From: Simon Davis
Sent: 25 August 2021 12:26
To: 'Susan Leeson' [REDACTED]
Subject: RE: Brookview Nursery WA/58/21/PL

I consider that the proposal accords with ALP EMP DM1 and with WNP CL1. However, CL2 does resist new B8 development so I would propose (with your agreement) restricting any PP to B1 (now E(g)) uses only.

Existing Block Plan
Scale 1:500

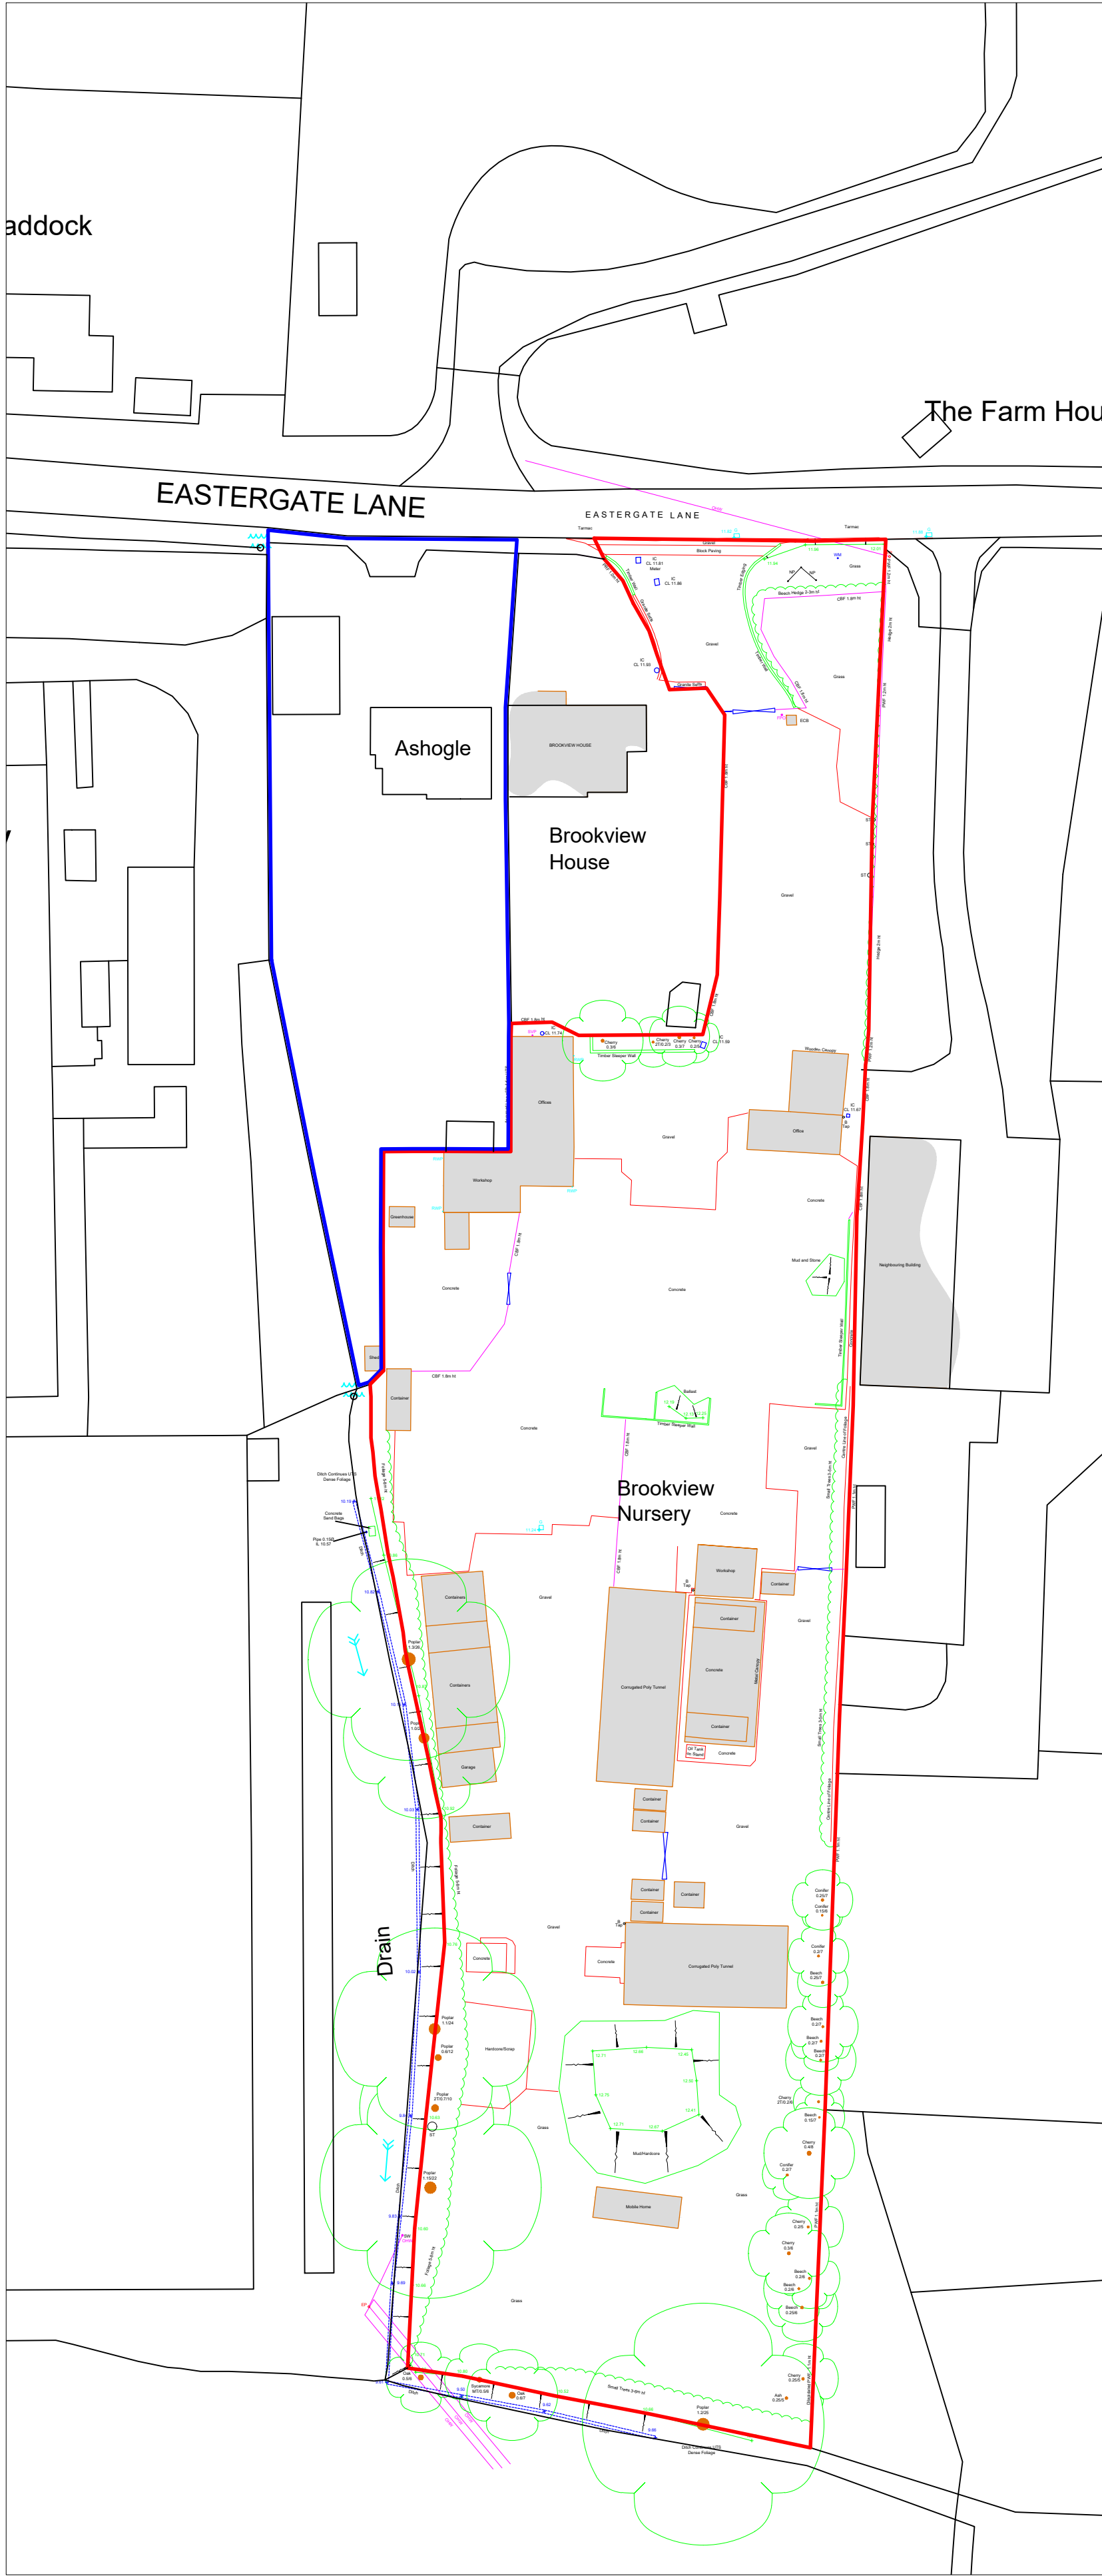
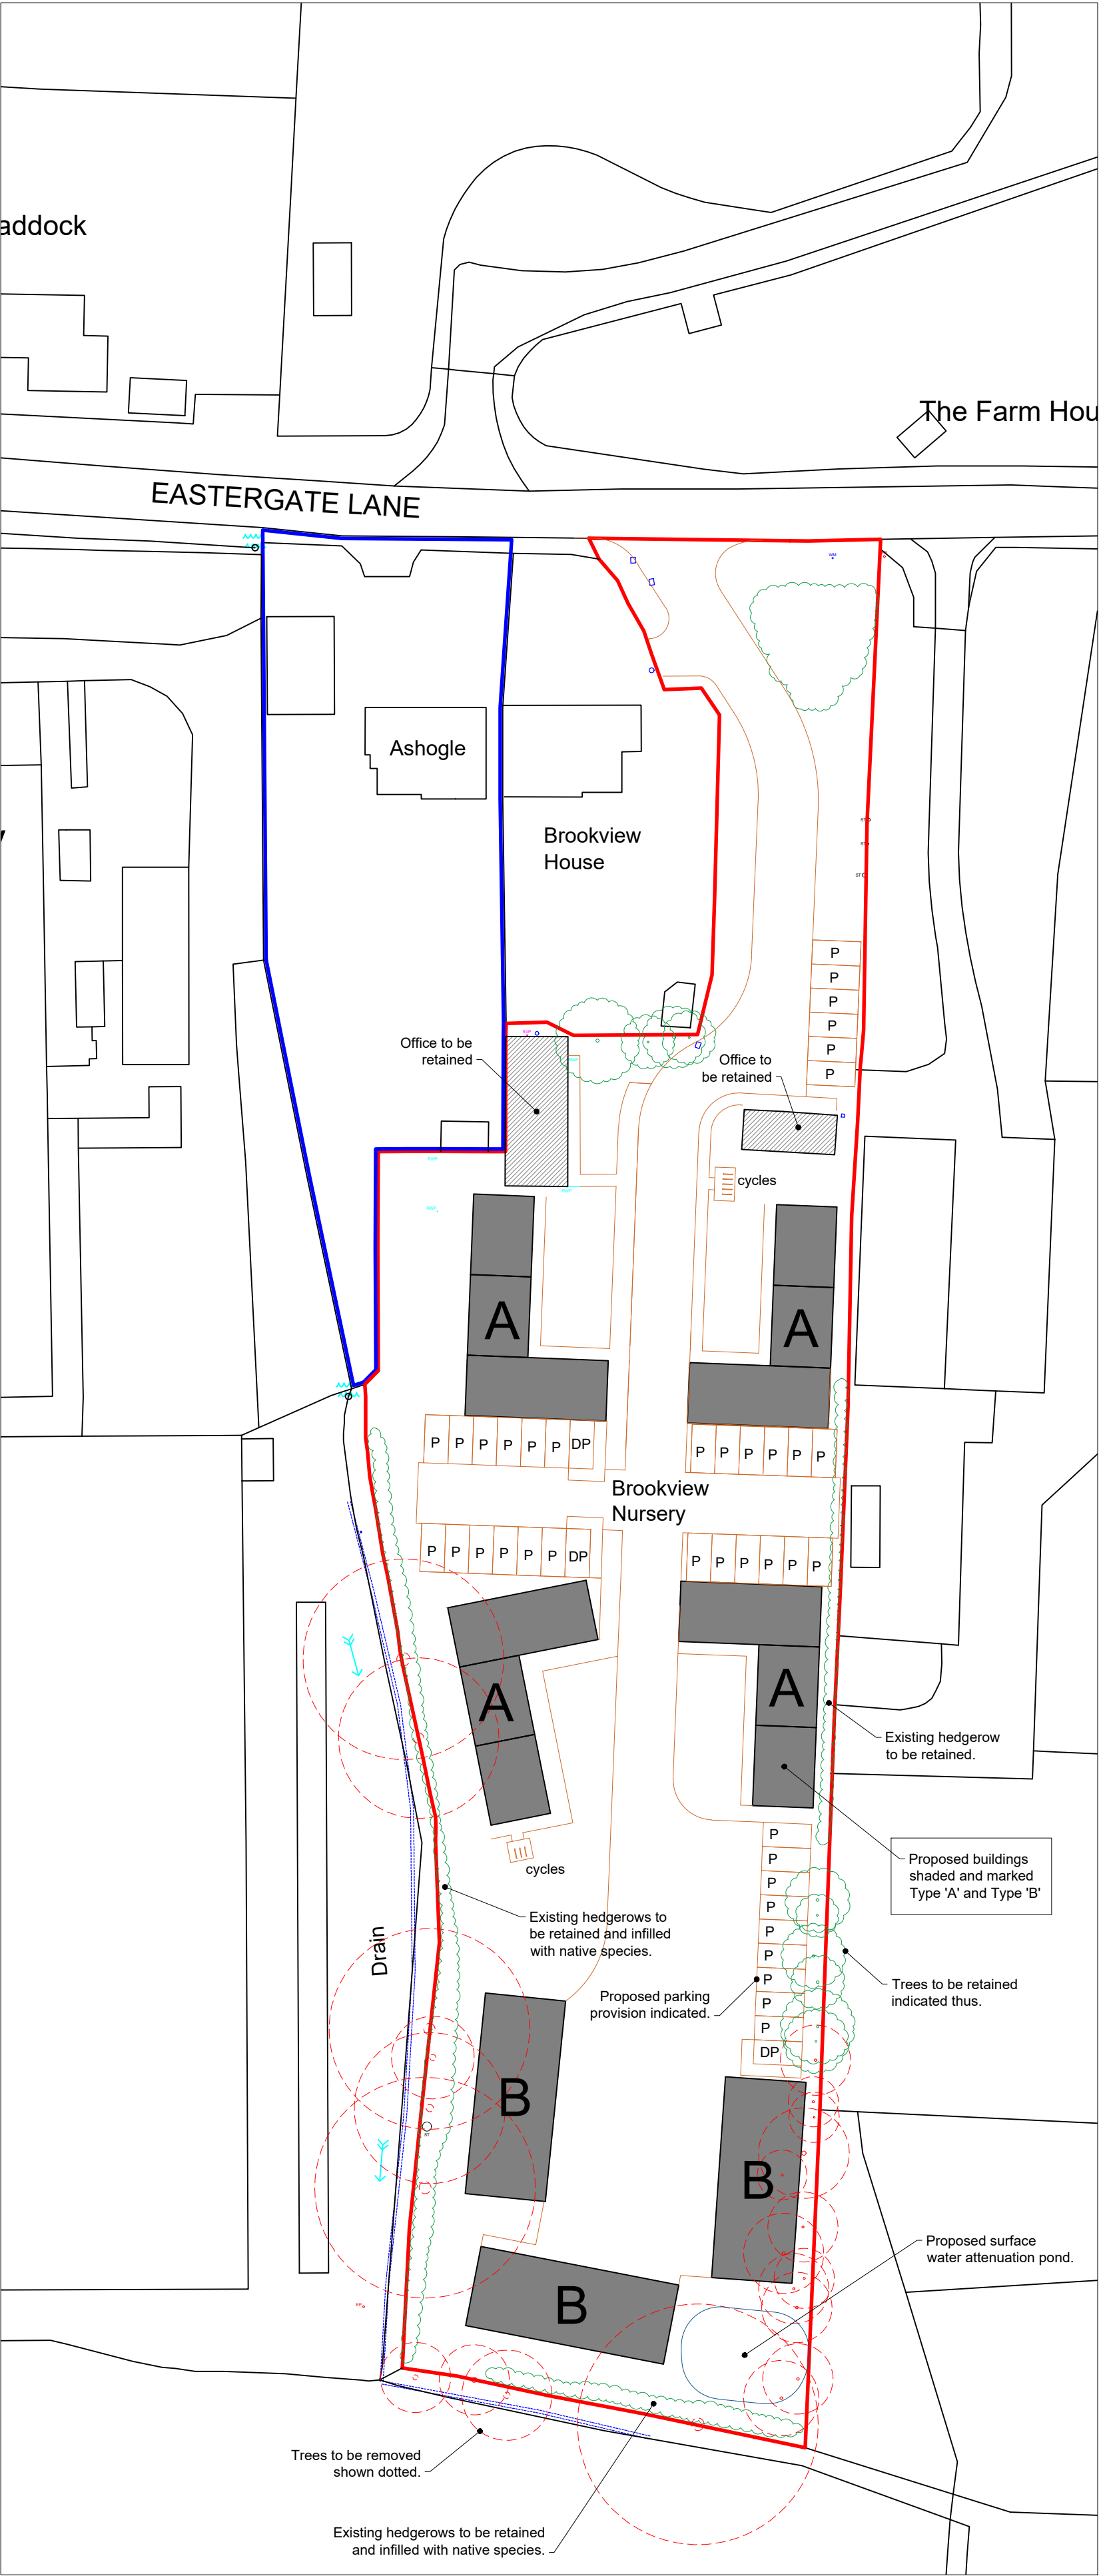
Anyway, I note that you are proposing to remove trees along the western and southern boundaries and so I think you would be in conflict with policy VE10 which states:

This conflict is likely going to make this very difficult to get through the DC Committee. You may be able to resolve this by layout changes/biodiversity net gain proposals.

Further speaking of which, you have not provided any tree survey so we cannot assess the impact on trees. I have consulted the Tree Officer but if he does respond, he will only say that no tree survey has been provided. Sorry for not spotting this previously but this does need to be provided.
